22 September 2021

Karen Harragon
Director, Social and Infrastructure Assessments
School & Infrastructure Assessments
NSW Department of Planning, Industry and Environment
4 Parramatta Square, 12 Darcy Street Parramatta 2150

RESPONSE TO SUBMISSIONS UNSW HEALTH TRANSLATION HUB (SSD-10822510)

Level 08	
scale	1 : 250@A1
drawn	TH
checked	JC
project no	190551.00
drawing no.	DA1009
issue	D

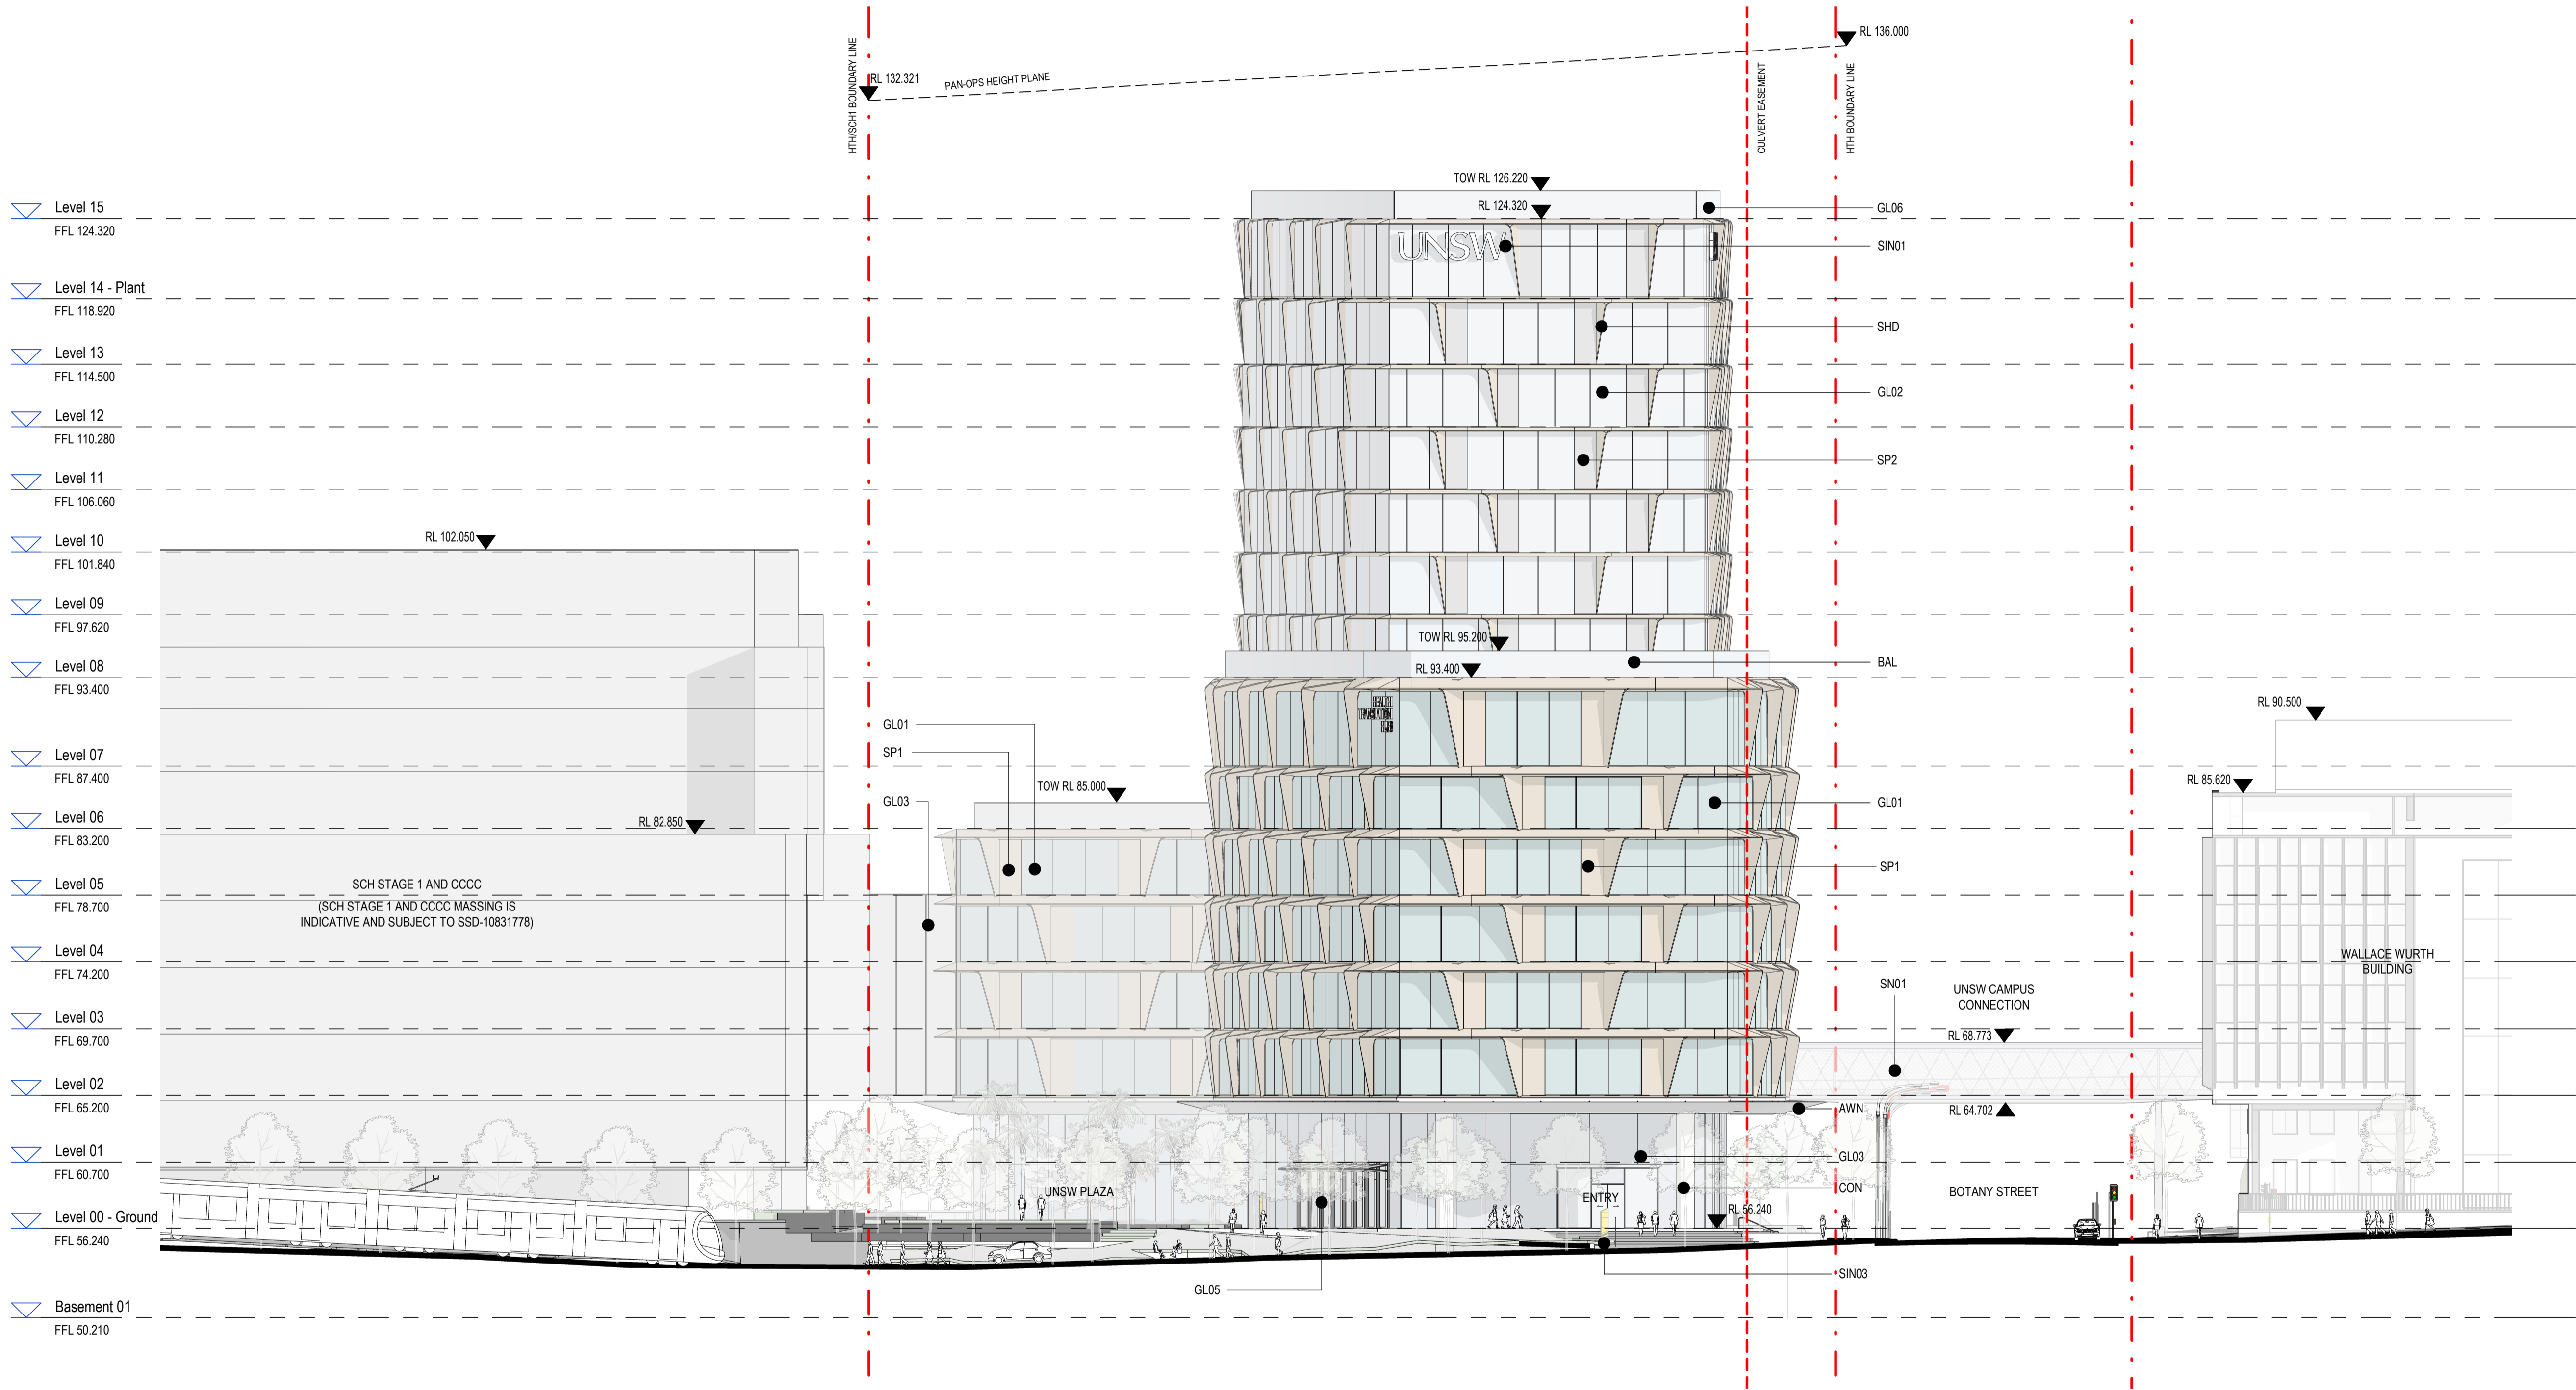
DPIE and Council have suggested that consideration be given to the provision of outdoor roof terraces to provide amenity for occupants, as well as opportunities for outdoor learning and breakout spaces.

The project team has considered these comments, and in response, has provided a north facing outdoor terrace at Level 8 of the UNSW HTH. The northern roof top that is accessible from Level 8 has been selected as the most appropriate location due to its northern aspect, expansive views and favourable weather/wind conditions.

As the building is not yet tenanted, the use of Level 8 is unknown. As a result, the terrace has been designed as a flexible space that can be adapted depending on the future tenant's needs. On this basis, the landscape treatment comprises a simple combination of accessible outdoor amenity to the north and non-accessible maintenance and access zones to the east and west.

scale	1 : 250@A1	drawing no.
drawn	TH	DA2004
checked	JC	issue
project no	190551.00	B

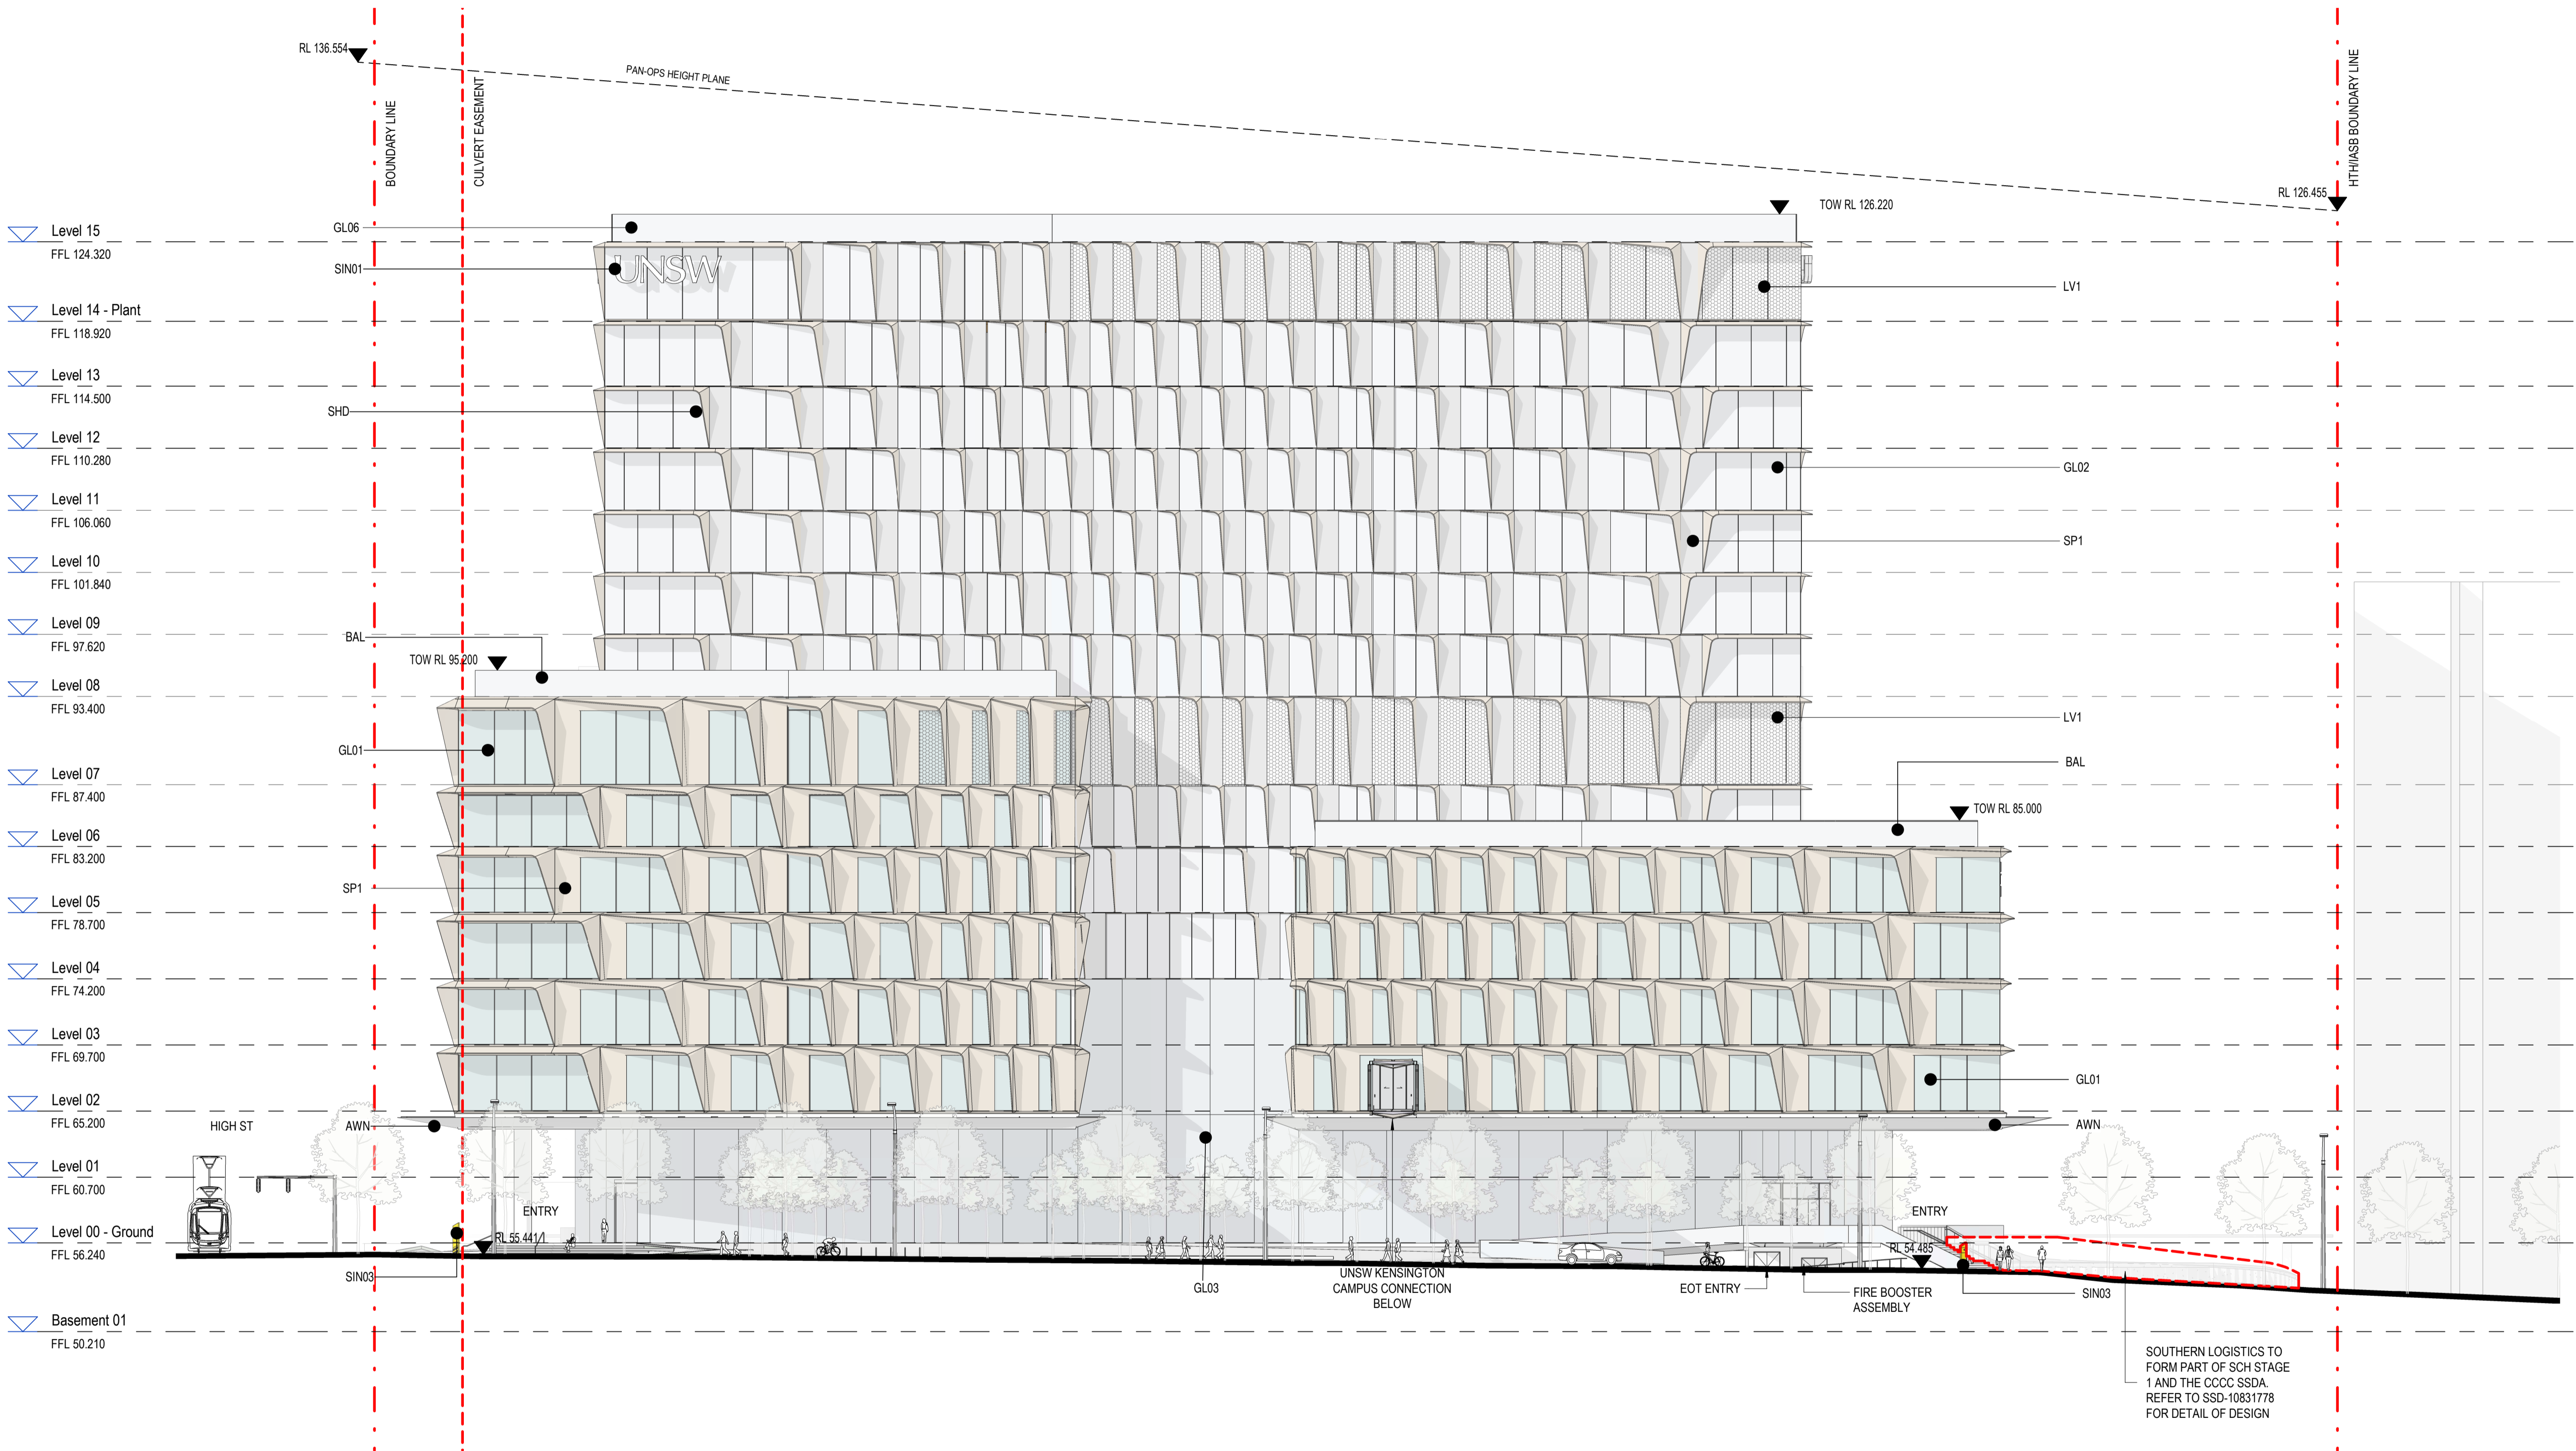
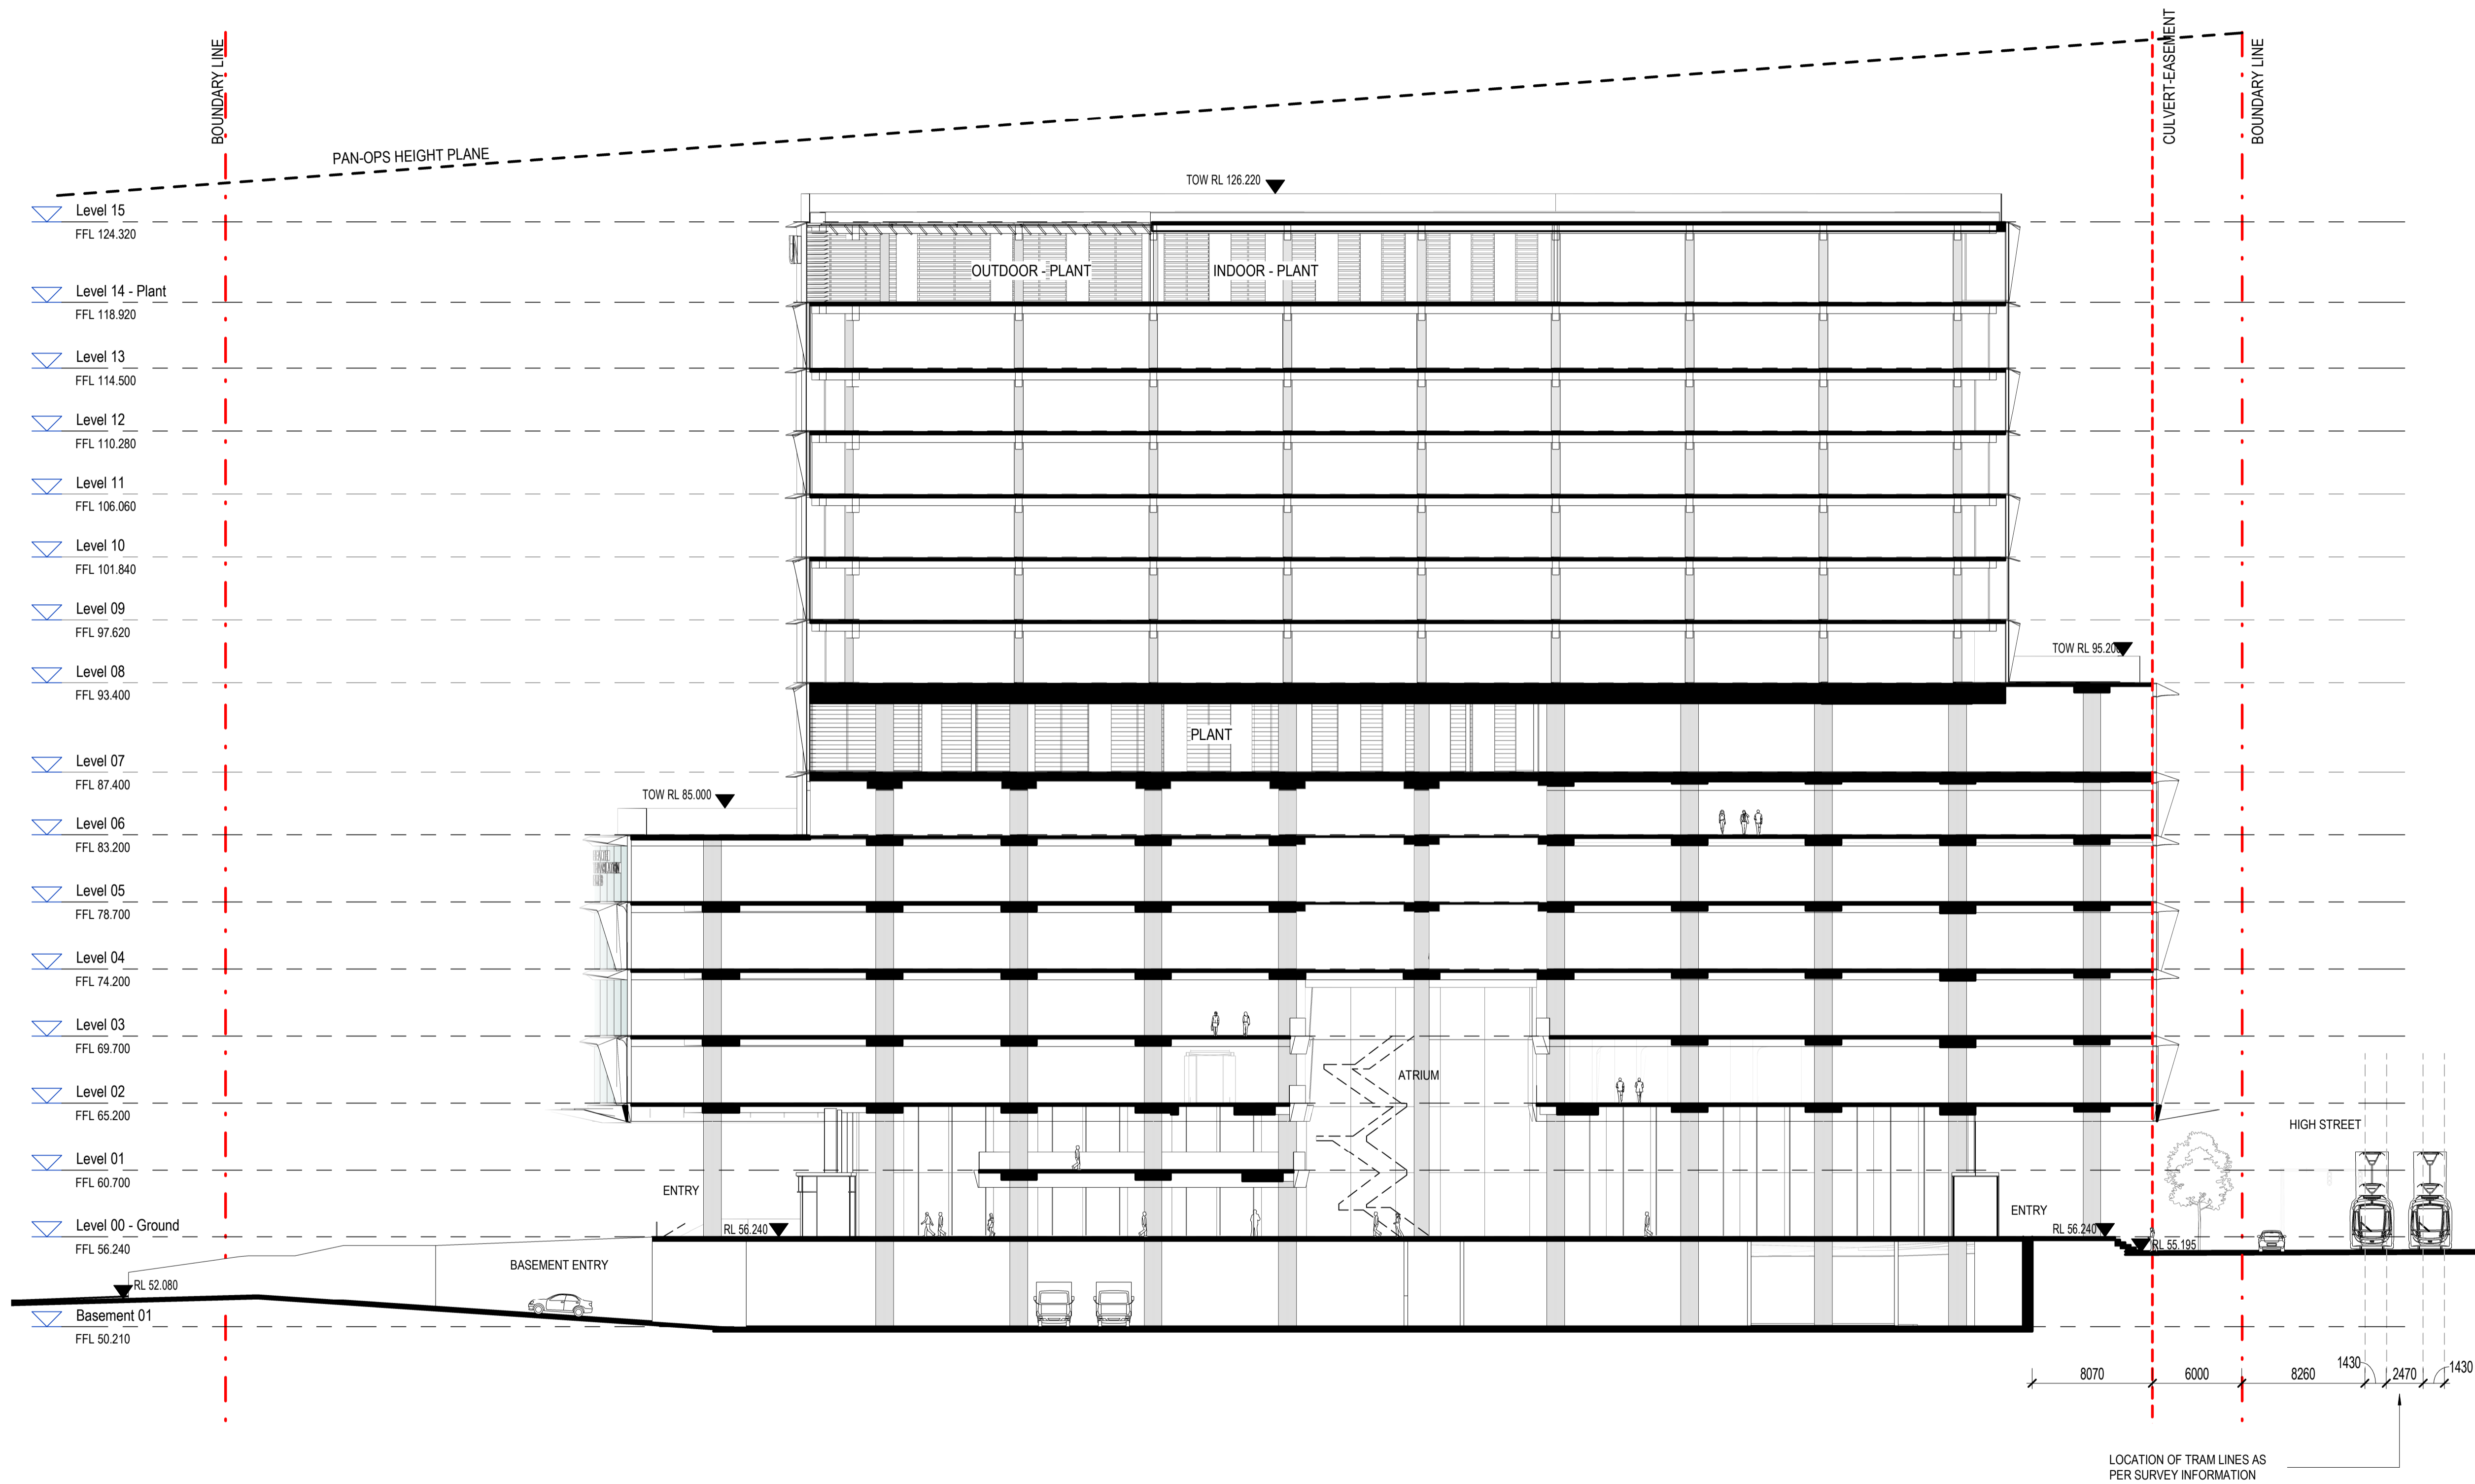
DPIE has requested that additional consideration be given to the design of the airbridge connection between the UNSW HTH and the SCH Stage 1 and CCCC building, with regard to the previous advice from the State Design Review Panel.

With reference to the most up-to-date façade design for the SCH Stage 1 and CCCC, the UNSW HTH design team proposes to remove the solar hoods that previously extended along the airbridge connection. This will provide an un-adorned elevation to the airbridge that is characterised by the transparency of its glazing. To reinforce the neutrality of the airbridge, the northern facade has been recessed to further separate the building facades and to give emphasis to the airbridge's legibility and purpose as a linking element in the composition of building forms.

The design refinements have been illustrated in **Figure 3** and on the updated elevations at **Attachment C**.
